Date: 23 January 2026
Our ref: 532483
IP ref: XXXXXXXXXX
Your ref: EN010158

NSIP Reference: EN010158

The Examining Authority's questions on relevant representations

TITLE:
FIGURE 2.4 FIELD NUMBERING
SYSTEM

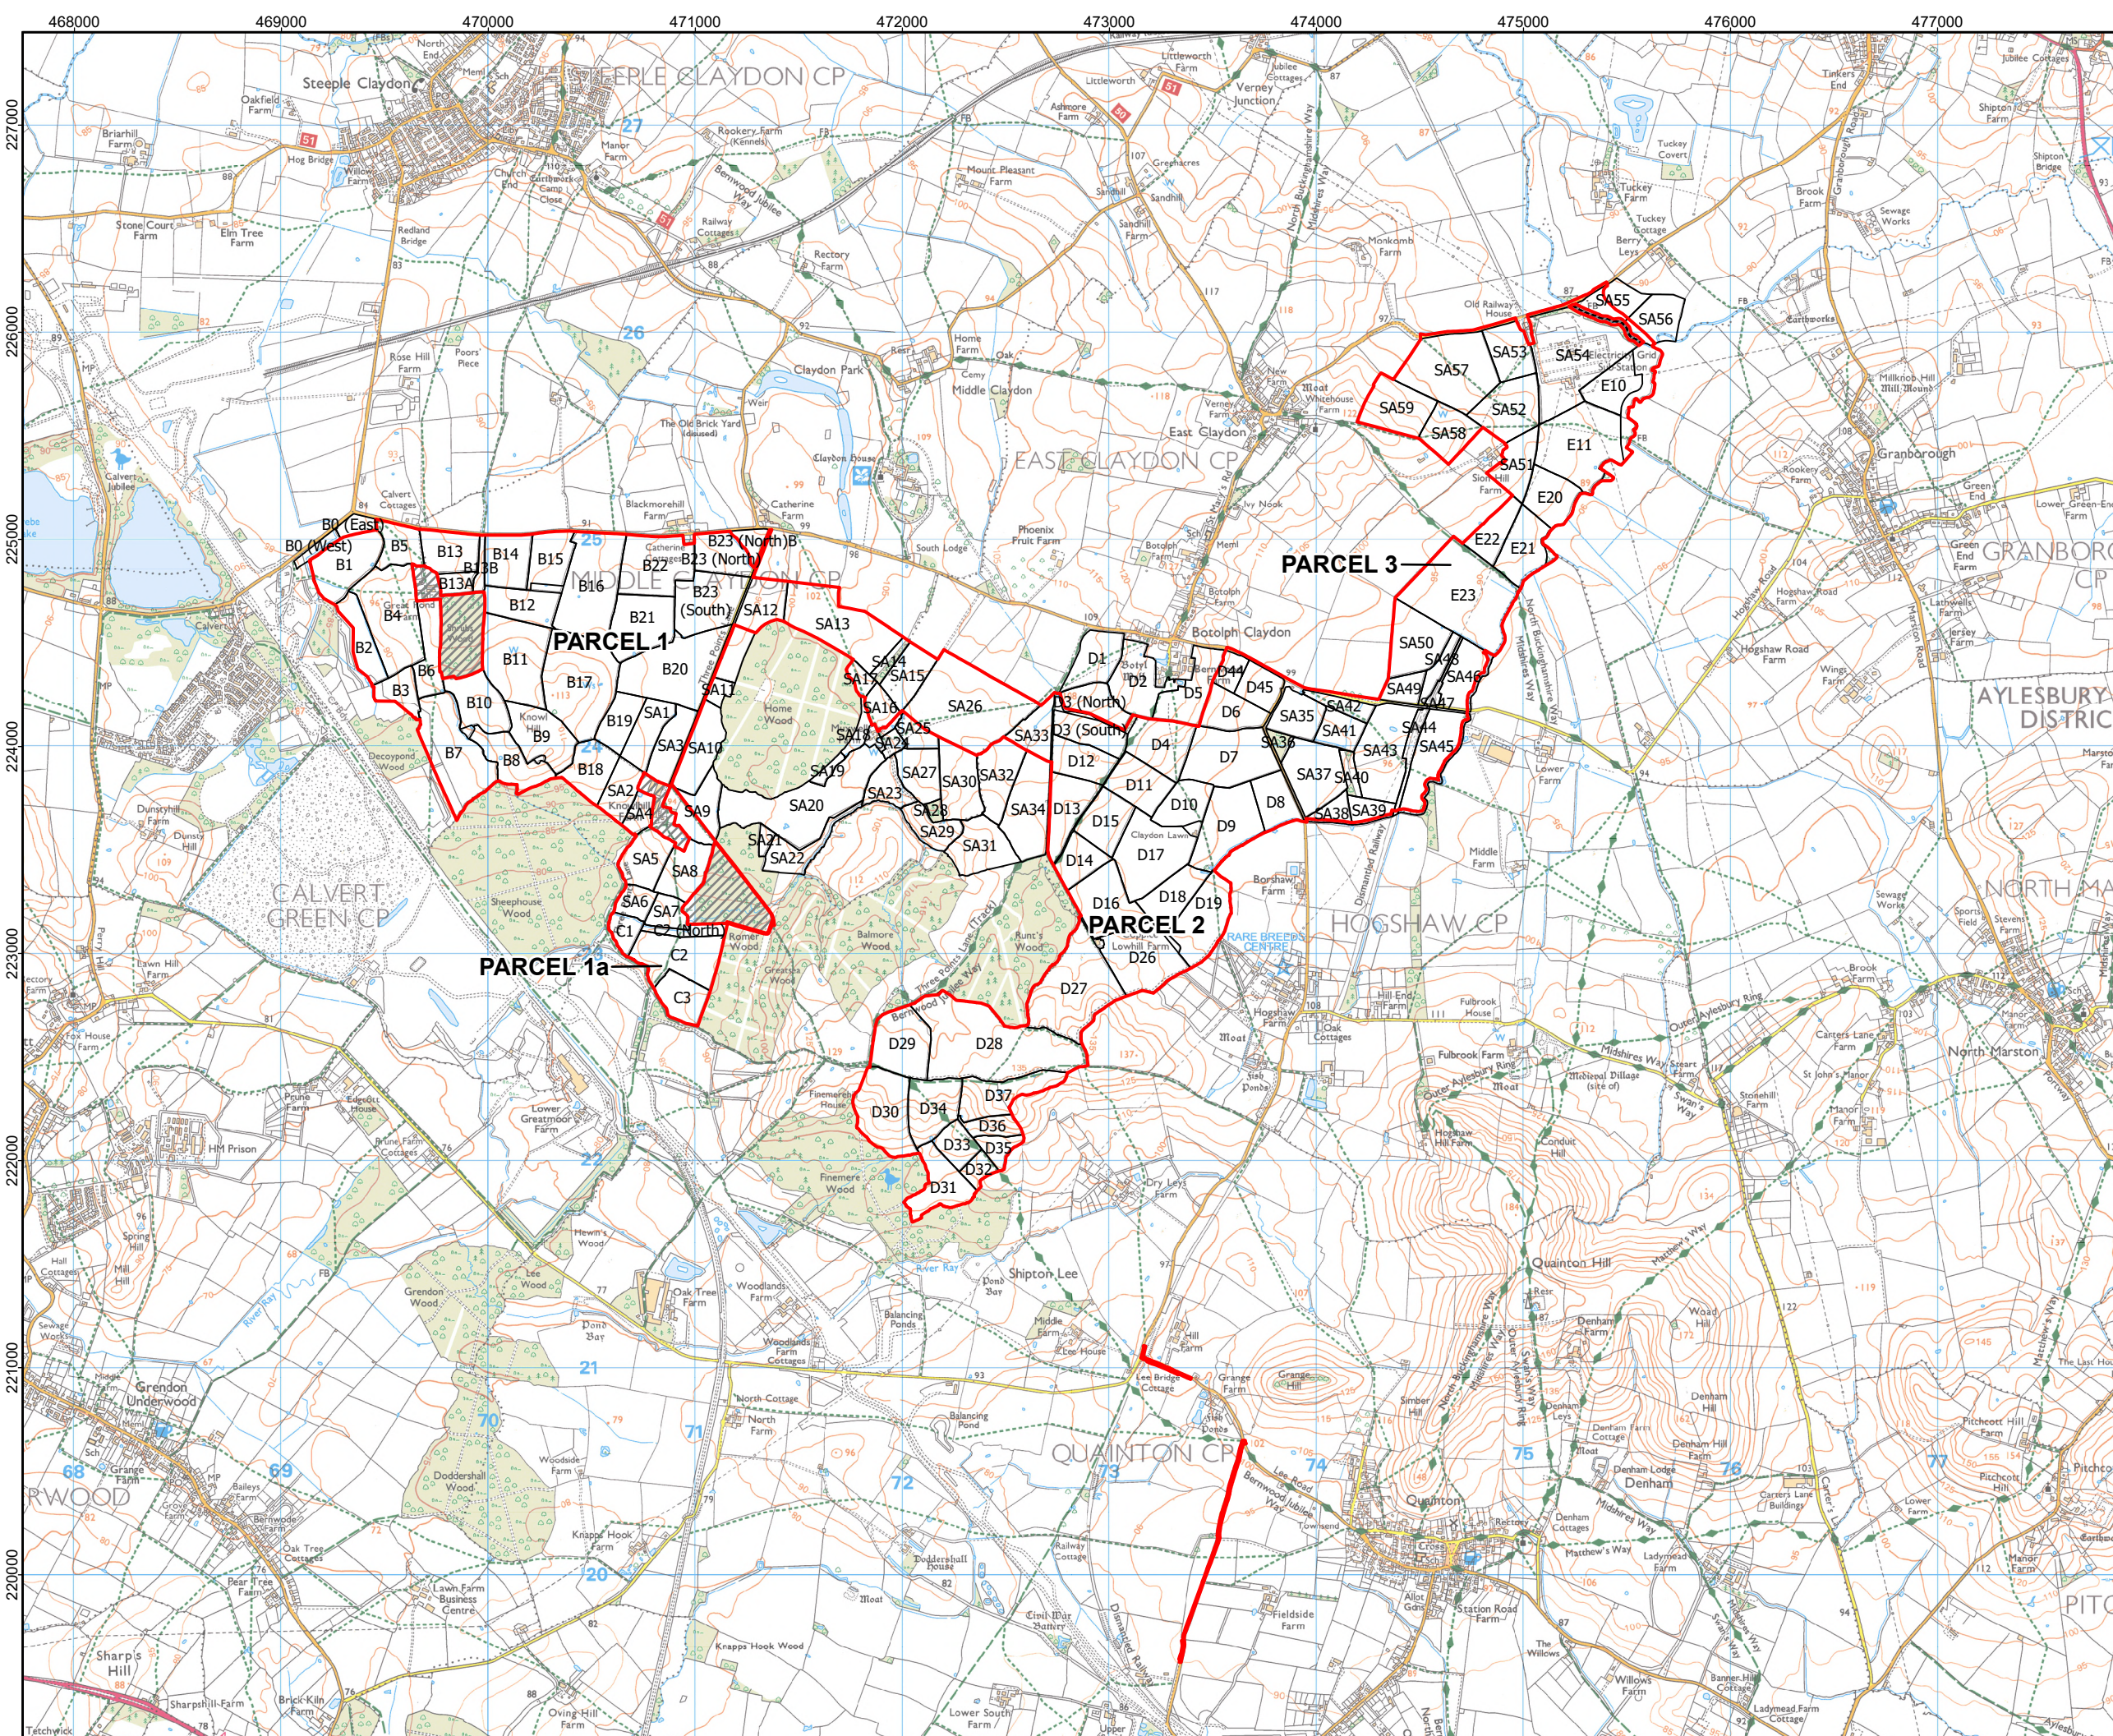
Our relevant representations [RR-203] described field parcels B7 to B10 as 'cattle grazed' in error. Fields B9 and B10 are currently under arable cultivation, while parcels B6, B7 and B8 are grassland, with B6 and B8 cattle grazed. It is the installation of panels in fields B6, B7 and B8 with which we are concerned. We apologise for this error.

Grassland fields B6, B7 and B8 have been identified as part of the core sustenance zone for Bechstein's bats during radiotracking surveys undertaken to inform the adjacent HS2 development and collated to inform the proposed SSSI extension. These areas have, alongside other areas outside of the order limits, been described in The Bernwood Population of Bechstein's Bats Non-Technical Summary of the Evidence (NECR558; 2024) as 'one of the most frequently used non-woodland core foraging areas'. This data has been

Although recognising the importance of this area and habitat type (grazed pasture compared to arable habitat) in correspondence with us, and specifically referencing some of the findings of the HS2 radio tracking surveys regularly within the ES, the impact of habitat loss in these fields is not considered. Frequently used parts of the core foraging area are not specifically mentioned within the ES, and the value of fields B6, B7 and B8 not confirmed nor are the potential impacts avoided.

In summary, we have evidence this area is important, and the survey data has not disproved this. The minimal additional acoustic data that has been gathered for this area has recorded *Myotis* bats using both hedgerows and open space, with survey unfortunately only able to be conducted when livestock were not present. The potential value of these grazed and rough grassland fields has not been adequately recognised or assessed in the ES.

We advise that everything possible should be done to avoid this impact, such as retaining areas of value, including both woodland, hedgerow and open areas, and locating measures to mitigate for loss of lower value or less used habitats/areas in the best possible locations. It is for this reason that we did not ask for further survey effort, but have instead recommended that panels are removed from B6, B7 and B8, which would not only avoid impacts of loss of this area, but also provide a suitable grazed, sheltered and connected location where habitat enhancement measures could be used to mitigate/compensate for impacts elsewhere. Given the National importance of the population, the unknown efficacy of the mitigation measures proposed and the existing pressures on this population from development, our recommendation is for avoidance as opposed to additional surveys.
